WEST SUSSEX COUNTY COUNCIL CONSULTATION

TO:	Arun District Council FAO: James Cross
FROM:	WSCC - Highways Authority
DATE:	16 January 2020
LOCATION:	Yapton & Ford Village Hall, Main Road, Yapton, BN18 0ET
SUBJECT:	Y/120/19/PL Installation of an Earth Bund & replacement of removable entrance posts with 2 No. galvanised lockable gates.
DATE OF SITE VISIT:	N/A
RECOMMENDATION:	Advice
S106 CONTRIBUTION TOTAL:	N/A

PROPOSED SITE PLAN
Scale 1:200

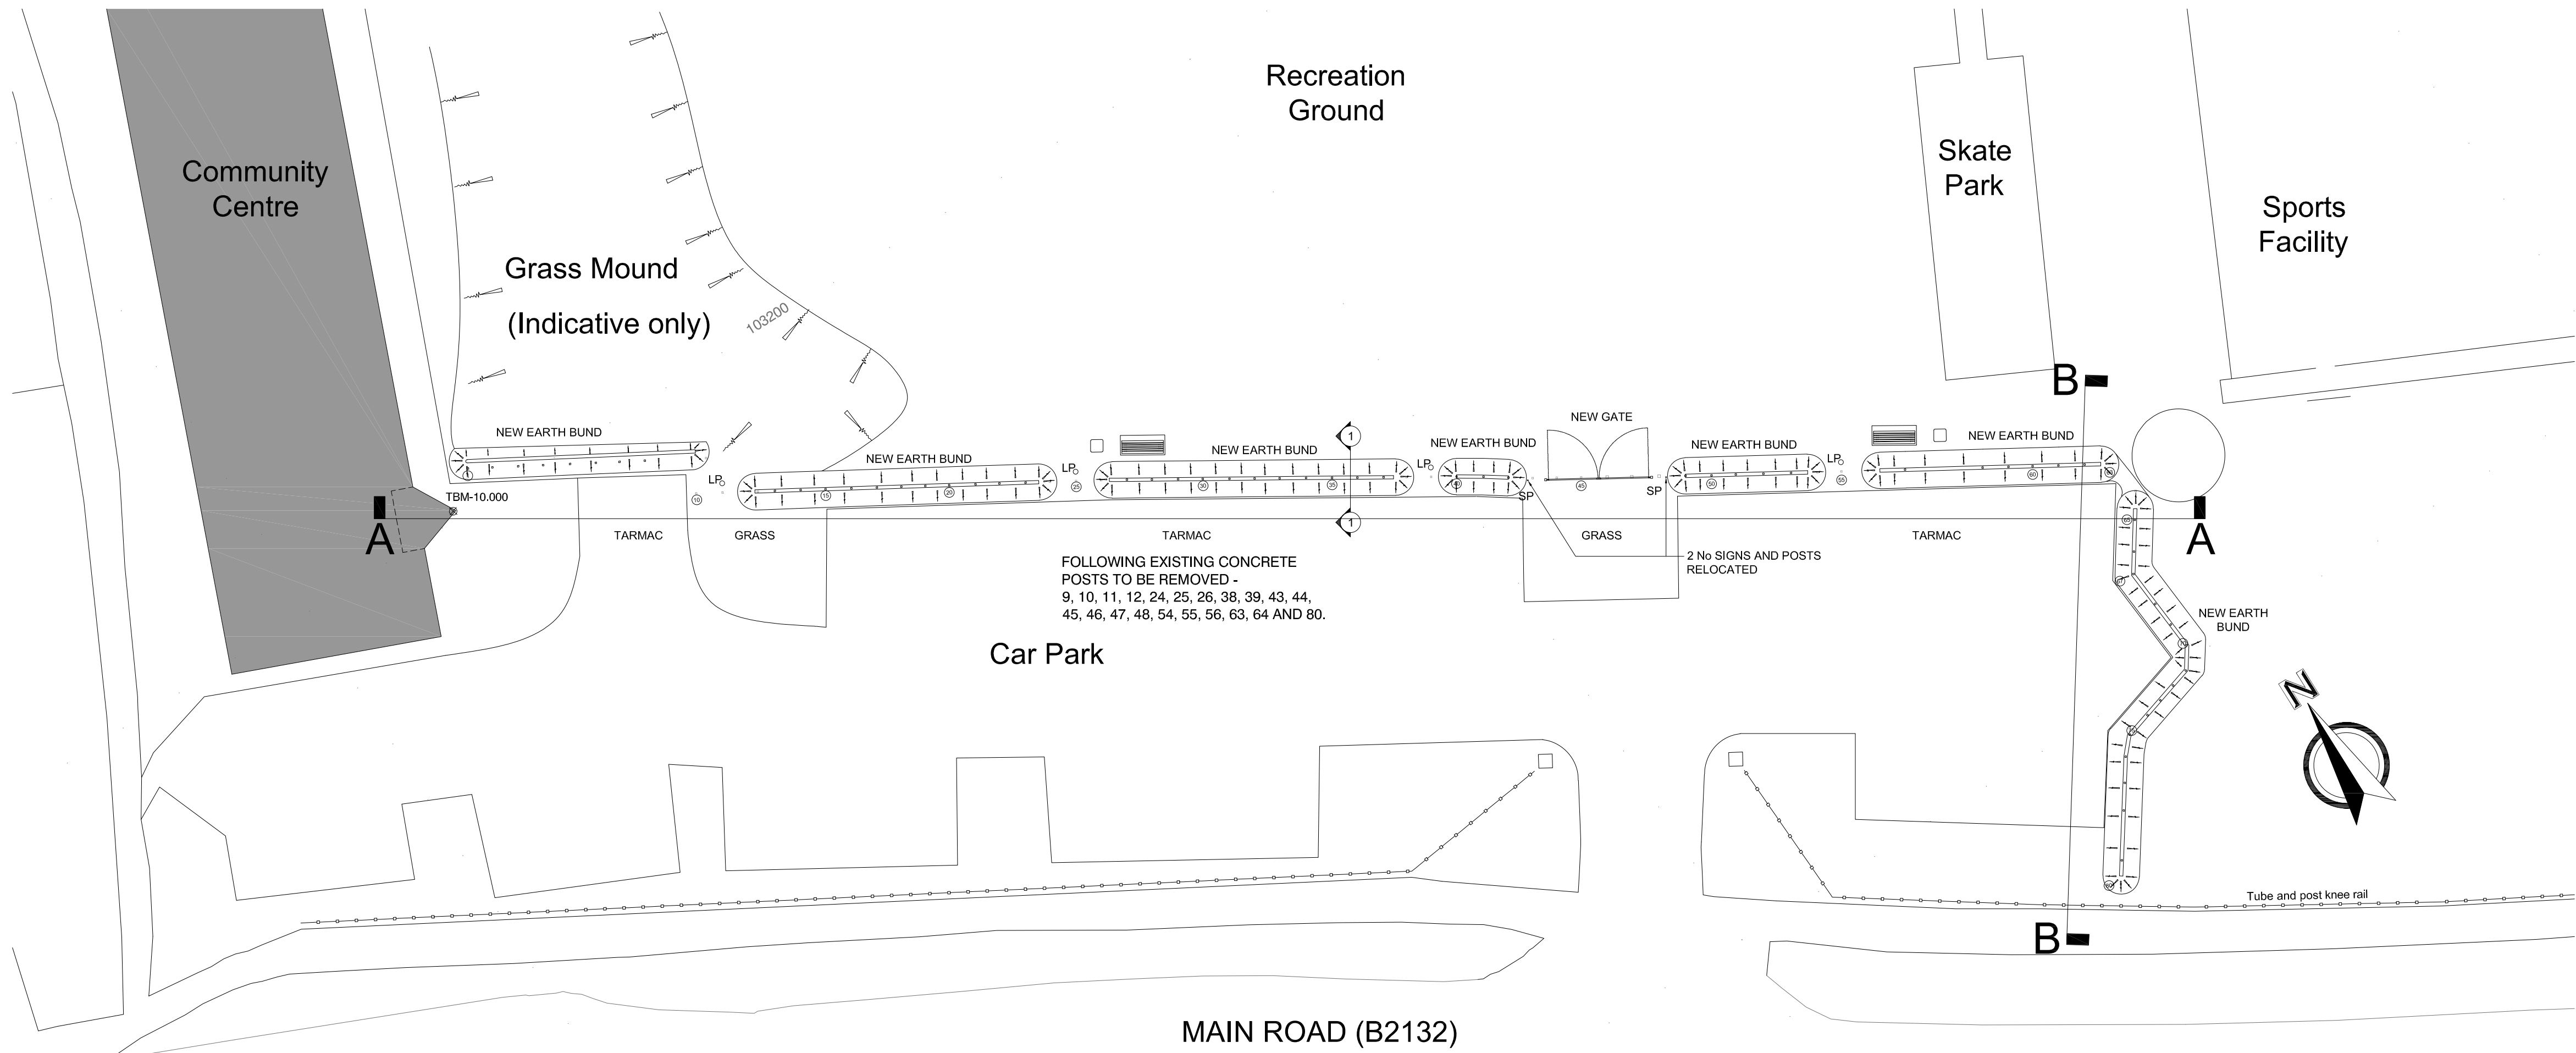
The proposed earth bunds and entrance gates are to be situated within private land and will not encroach onto maintained highway. The applicant does not propose any other alterations to the site for this development. The proposal will not result in the loss of any off-street parking spaces, nor will it compromise the ability for vehicles to turn on-site.
